Modification of Minister's Approval

Section 75W of the *Environmental Planning & Assessment Act 1979*

MP06_0273 granted by the Minister for Planning on 19 October 2007

MP06_0273 MOD 3:

Figure 6: Additional tree proposed for removal (dotted blue)

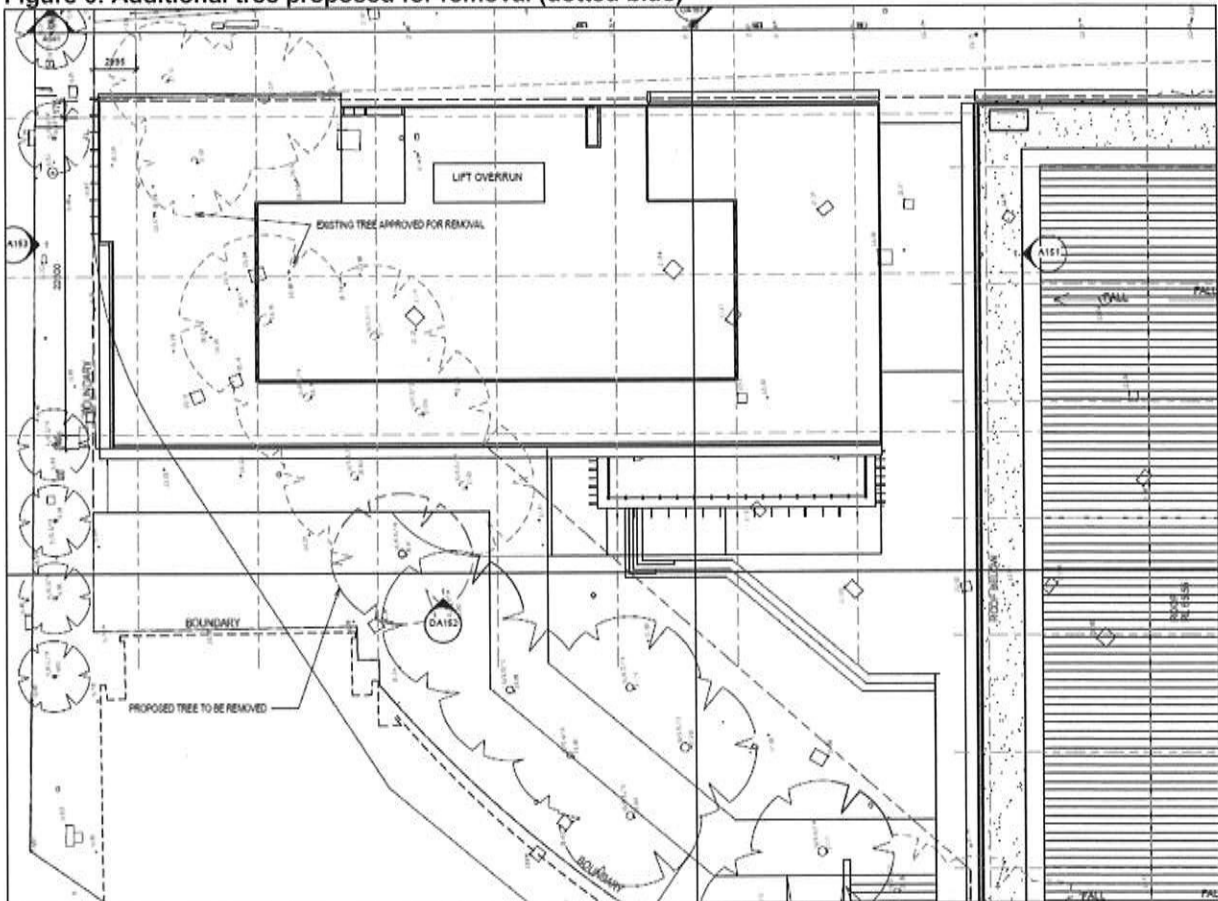
The Brushbox tree shown to be removed on Drawing No. DA050 C Site Plan (outlined in a dashed blue line) is to be replaced elsewhere within the approved public domain area on the subject site during stage 1 works.
